19 April 2010

AW/55/10/T - Lightly crown lift (T1) 2 Evergreen Oak Trees and prune back easterly growth , Fell (T2) 1 Evergreen Oak at Craigweil Manor Flats ,The Drive, Aldwick.

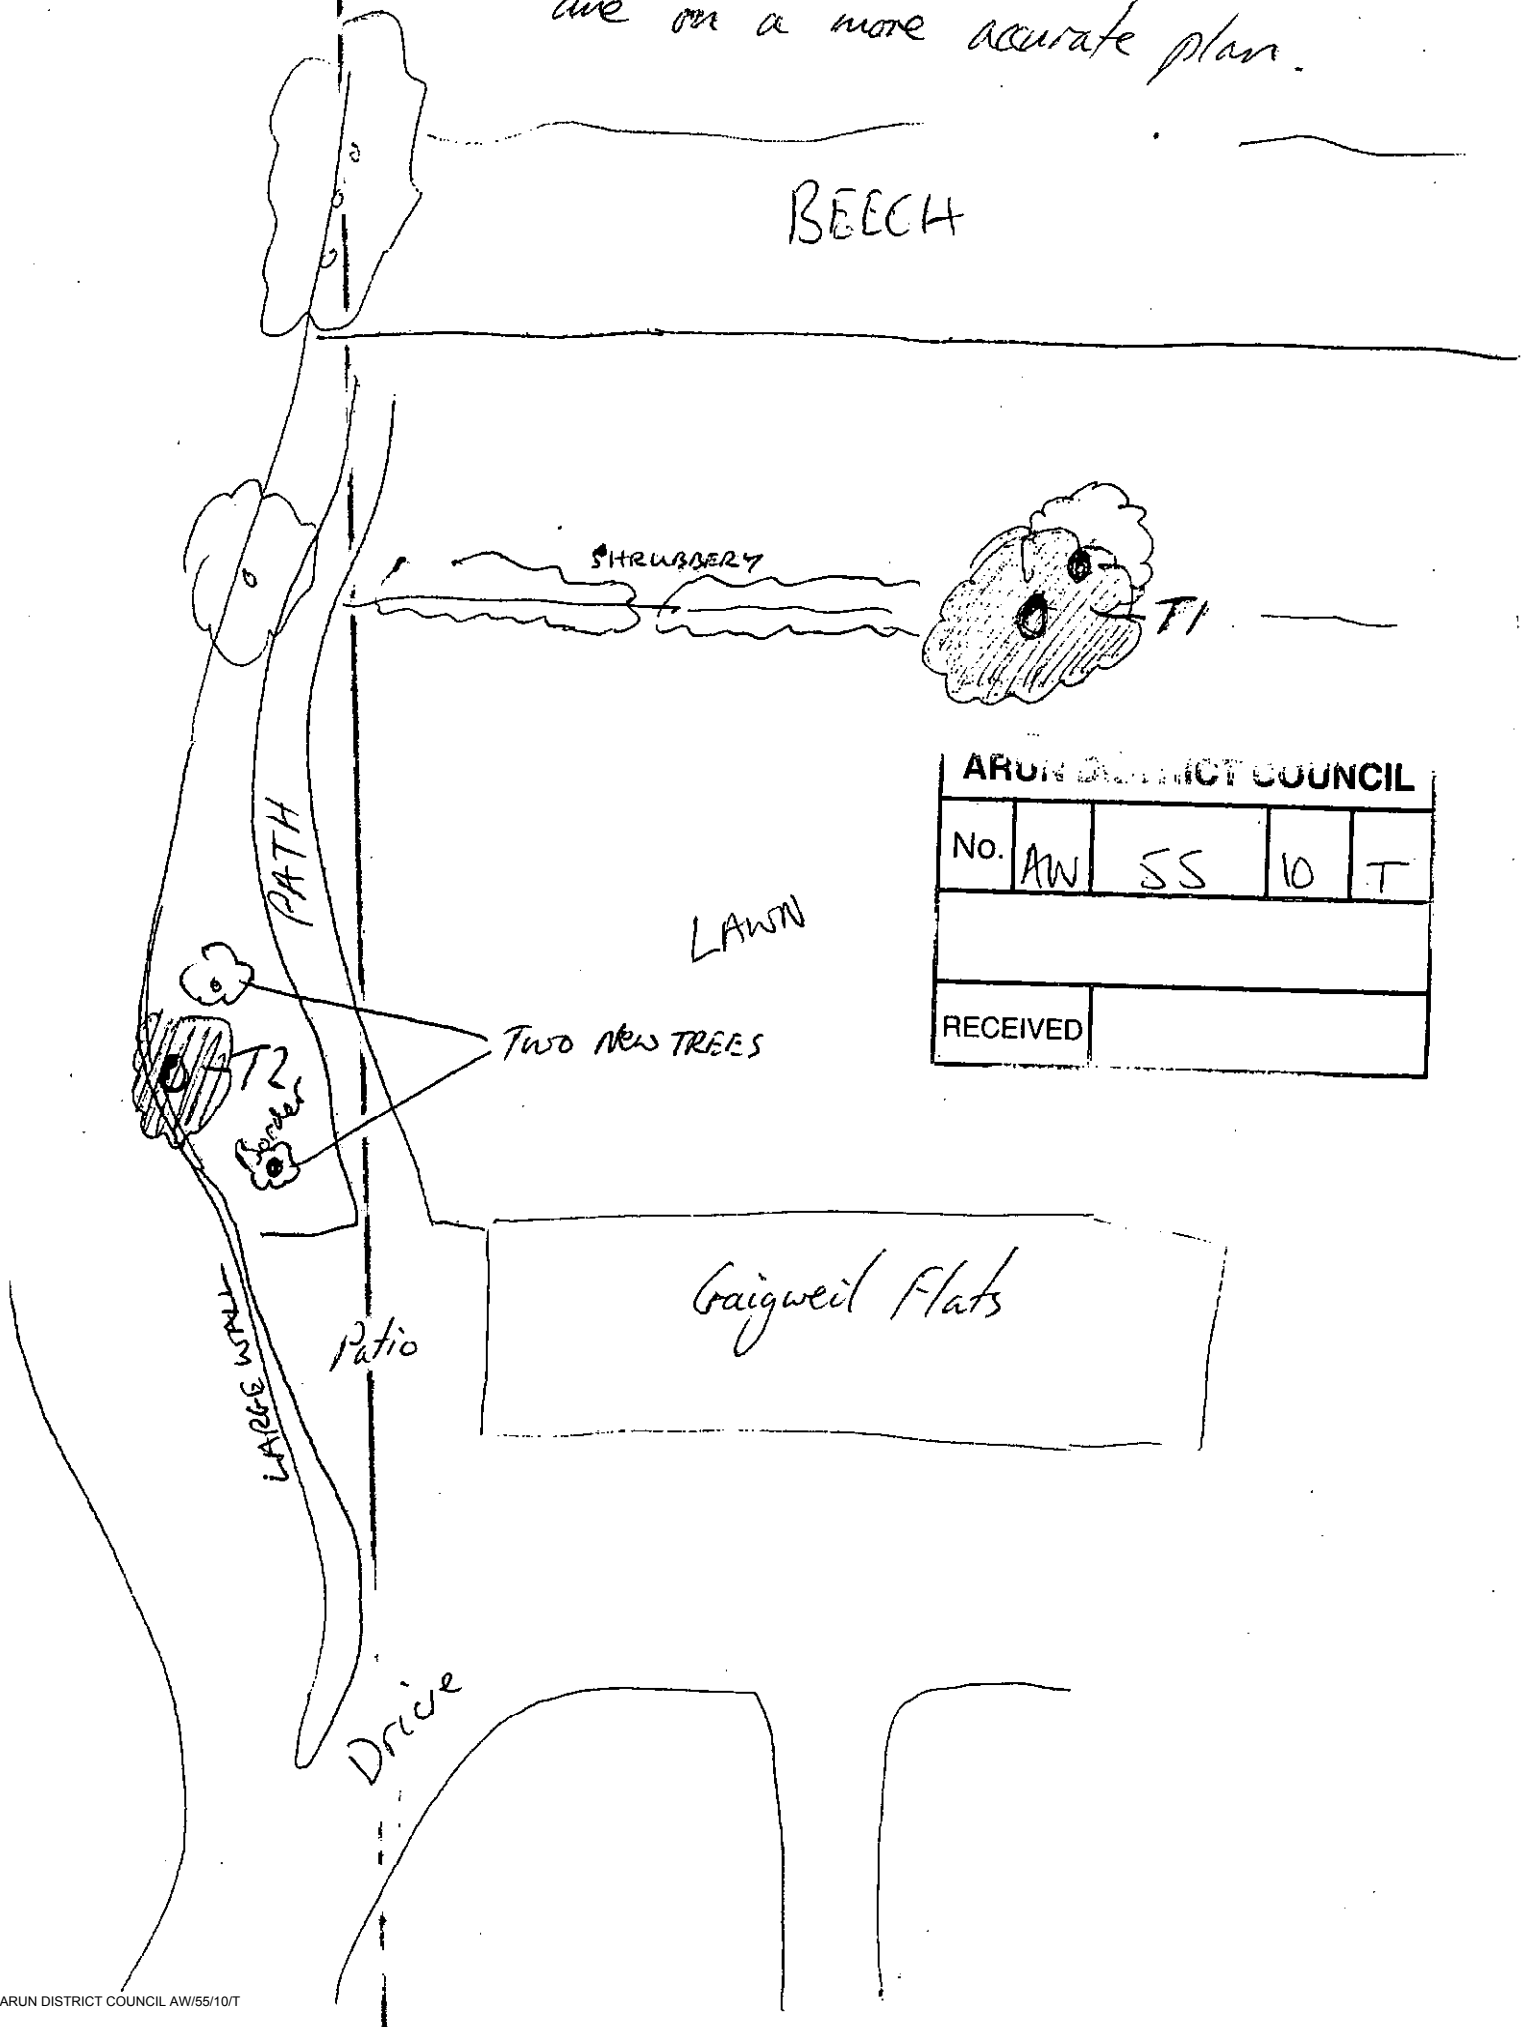
Thank you for your recent memo, the site of which I visited recently and confirm that the tree marked T2 Evergreen Oak on the plane is dead and should be removed . Two new trees (Maritime Pine) have been planted in the position to take the place of the dead one.

The trees marked (T1) Evergreen Oaks appear to be two trunks coming from what could be a common source below ground, and the work of pruning is to restore the balance of the tree as it is in a very exposed position.

I have no objection to the proposed work it being for the future good practice in keeping the tree stock in good health.
